## **RESPONSE TO REQUEST FOR INFORMATION: 90-102 REGENT STREET, REDFERN (SSD-10382)**

This correspondence has been prepared by Urbis on behalf of The Trust Company (Australia) Limited ATF Wee Hur Regent Trust (**Wee Hur**) and relates to the above State Significant Development Application (**SSDA**) at 90-102 Regent Street, Redfern.

It responds to a Request for Information (**RFI**) issued by the Department of Planning, Industry and Environment (**DPIE**) on 25 May 2021. DPIE requested a response to the additional submission by the City of Sydney following their review of the Revised Response to Submissions (**RRtS**) report submitted by Wee Hur on 27 April 2021.

LEVEL 2 | VIEWS - WESTERN TERRACE

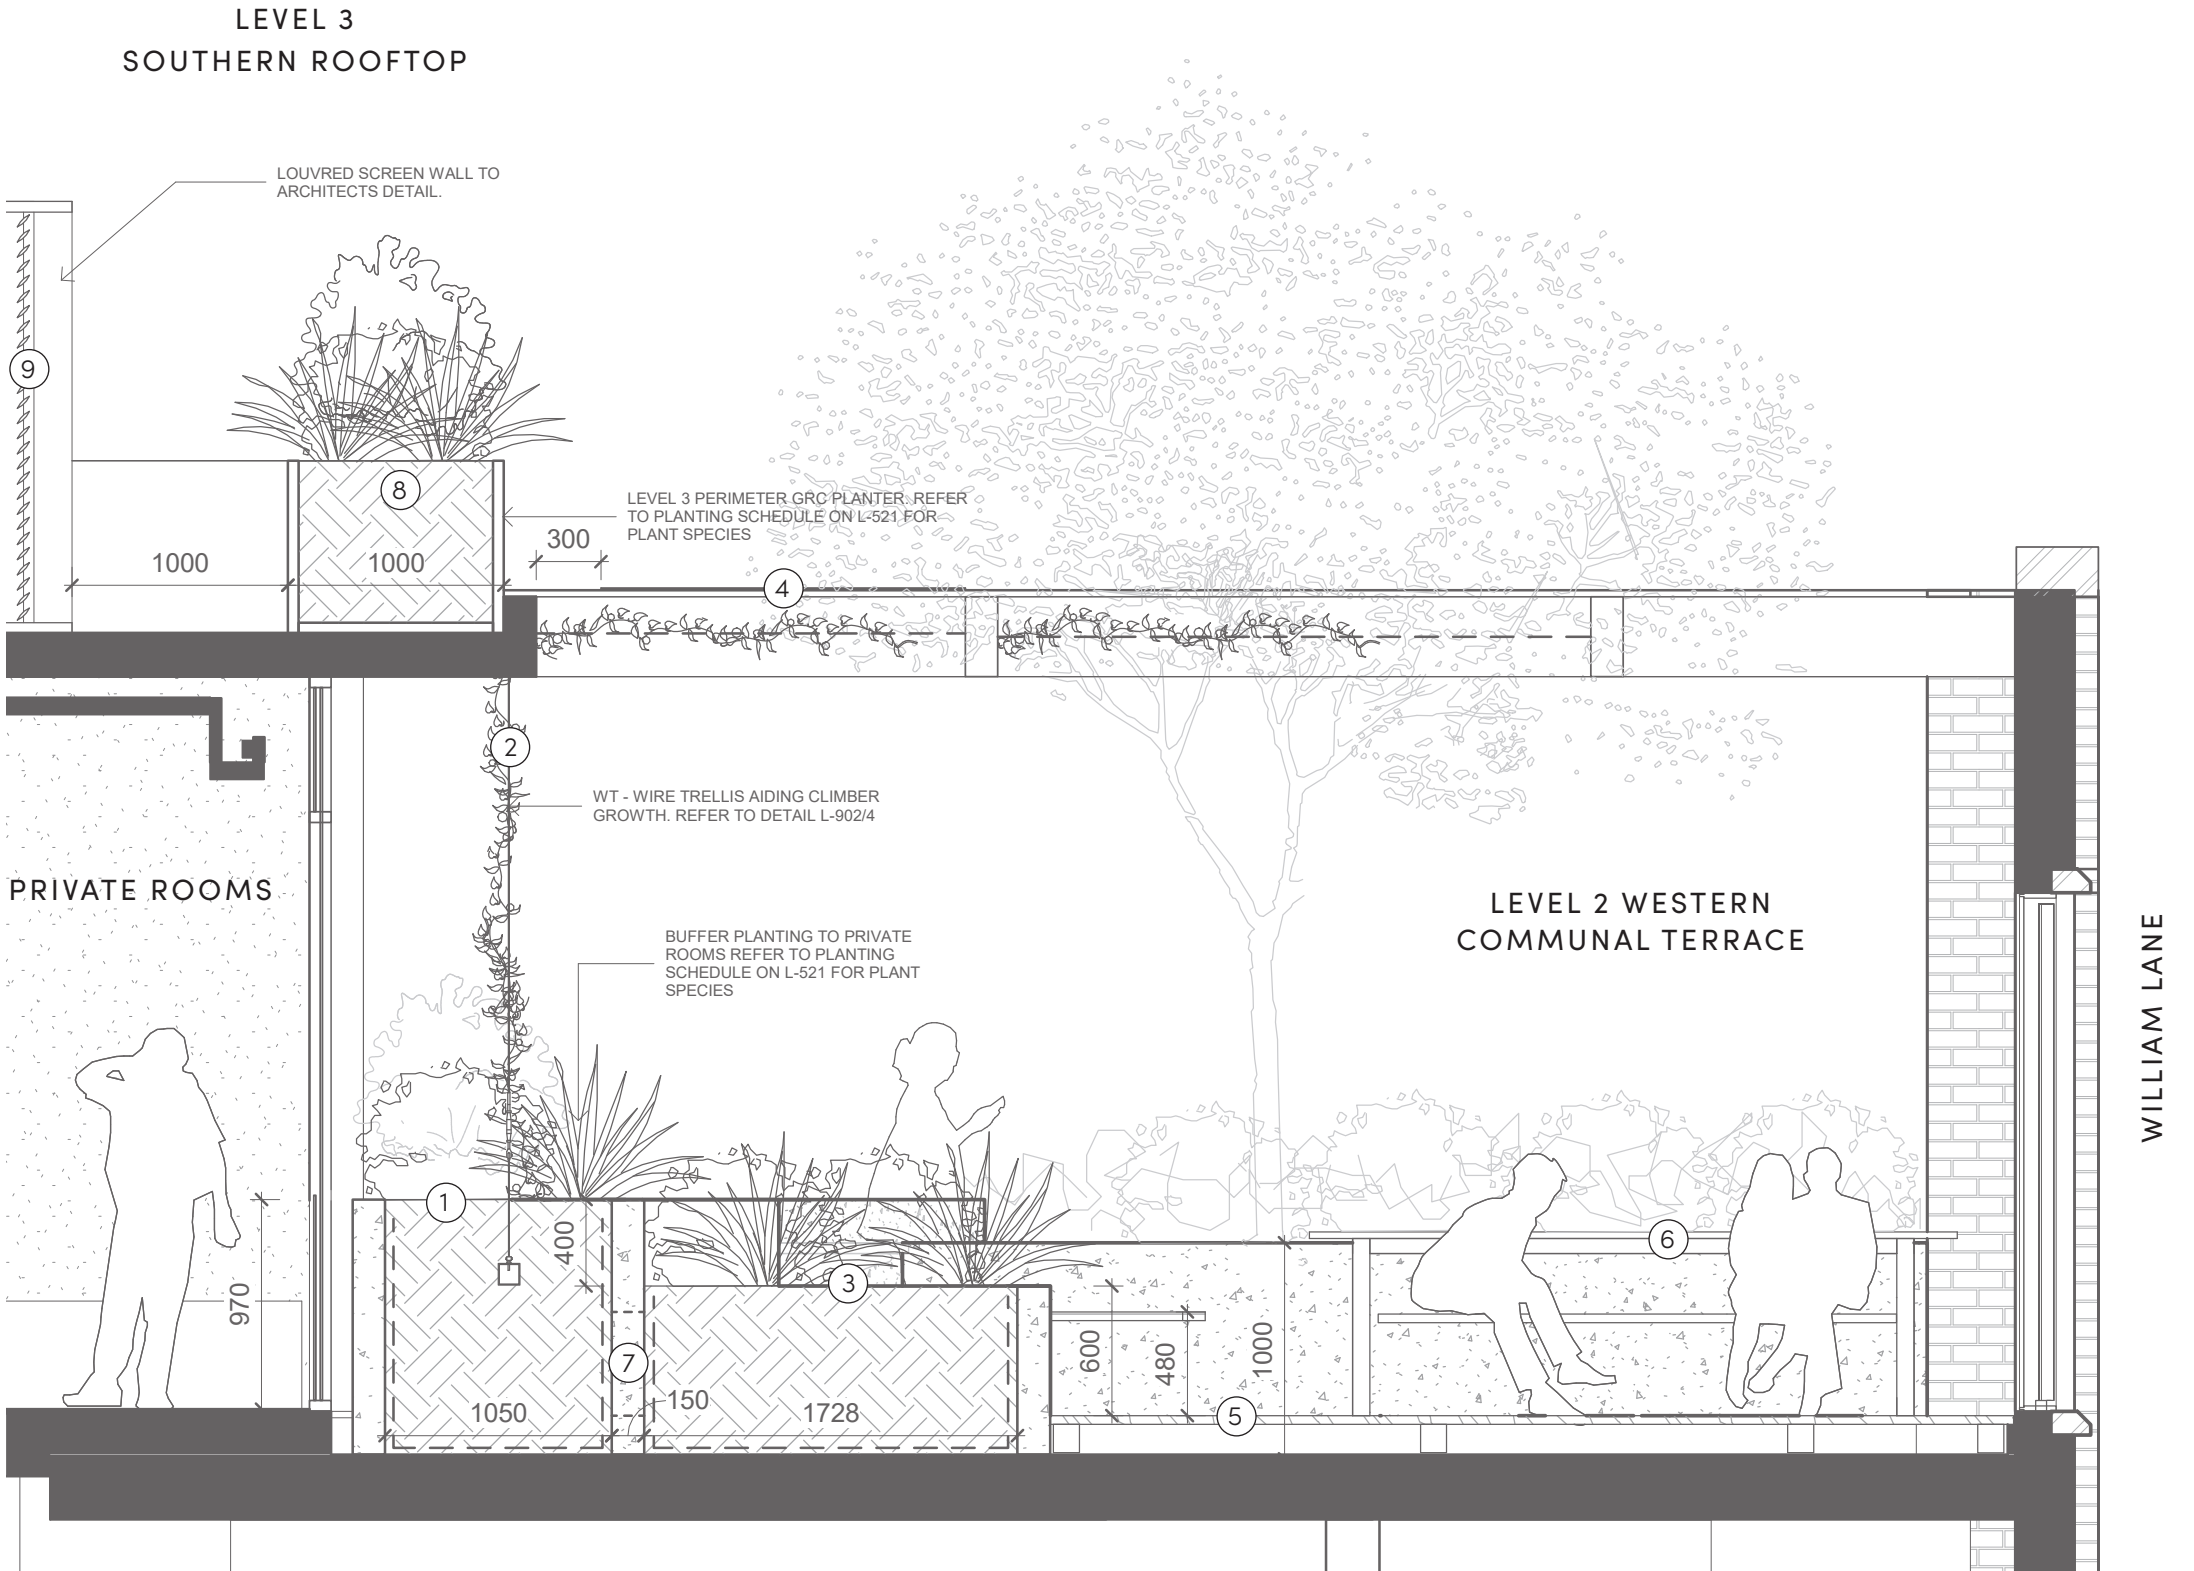
2c	The garden beds proposed on Level two are not large or deep enough to sustain trees and must be amended to provide adequate soil volumes for the planting of trees as laid out within the Sydney Landscape Code. The smaller raised planters should be consolidated and made contiguous to allow for the soil volume and depth that can sustain mature trees.	The Landscape Plans have been updated to raise planters and provide wall cut-outs through back-to-back planters with a 50% permeability ratio to increase shared soil volumes as shown below.

LEVEL 3 | LANDSCAPE PLAN

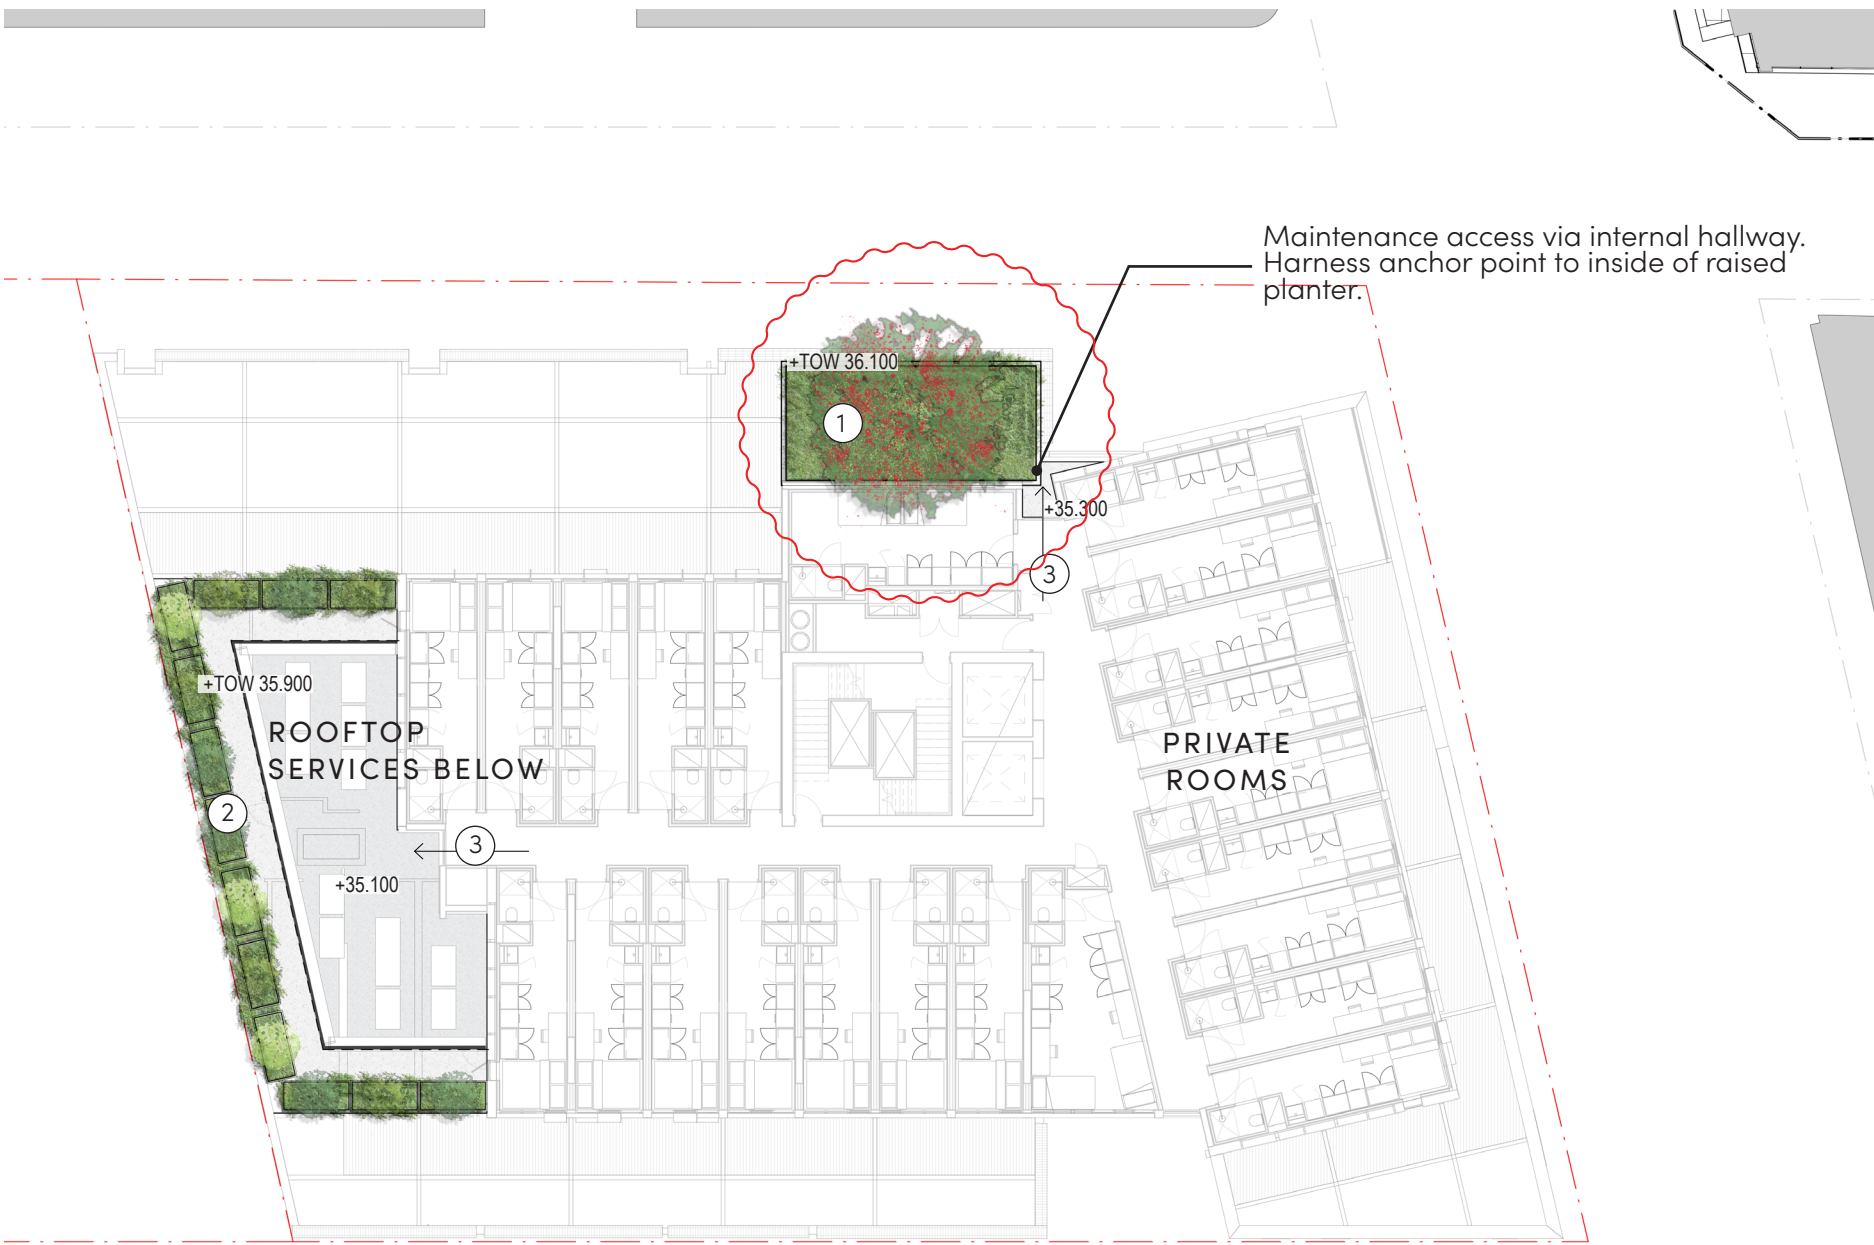
Item	Issues	Action/ Response
		 <p>WT - WIRE TRELLIS AIDING CLIMBER GROWTH. REFER TO DETAIL L-903/4</p> <p>BUFFER PLANTING TO PRIVATE ROOMS REFER TO PLANTING SCHEDULE ON L-921 FOR PLANT SPECIES</p>
2d	<p>The three 'Tristaniopsis laurina – Small' within the Level 3 rooftop must be replaced with one medium sized tree and the rooftop terrace amended to be a garden bed that provides soil volumes consistent with the Sydney Landscape Code.</p>	<p>The Level 3 west facing terrace has been amended and the small planter boxes consolidated to form one in-situ planter which covers the entire rooftop area with a soil depth of 1m. The three Tristaniopsis laurina trees have been replaced by one Stenocarpus sinuatus (Firewheel Tree), expected to reach a height of between 8-10m. These changes have been reflected in the updated Landscape Plans at <b>Appendix B</b>.</p>
2e	<p>The limited detail on the glass canopy over the communal open space means that the stated gaps, which are necessary to allow heat to escape, is not confirmed. This detail, and the subsequent viability of the planting, remains in question. Substantially, more detail is required to confirm the viability of the landscape proposal, however given the lack of clarification to this point, this should be done to the satisfaction of DPIE.</p>	<p>The supplementary response provided by Turf Design confirms adequate airflow and natural irrigation can be provided to the planter areas to supplement the automatic subsurface drip irrigation system. The glass awning will also allow adequate natural light to the planter areas.</p>

- The west facing terrace on Level 3 has been amended by consolidating the small planter boxes into one in-situ planter with a soil depth of 1m. The three *Tristania laurina* trees have been replaced by one *Stenocarpus sinuatus* (Firewheel Tree), expected to reach a height of between 8-10m.
- The two existing *Pistacia chinensis* trees along Marian Street are to be retained.
- The signage zone on the window to the east of the Regent Street entrance has been removed.
- The signage zone at the Regent Street entrance has been further developed to improve its integration with the fascia of the awning.
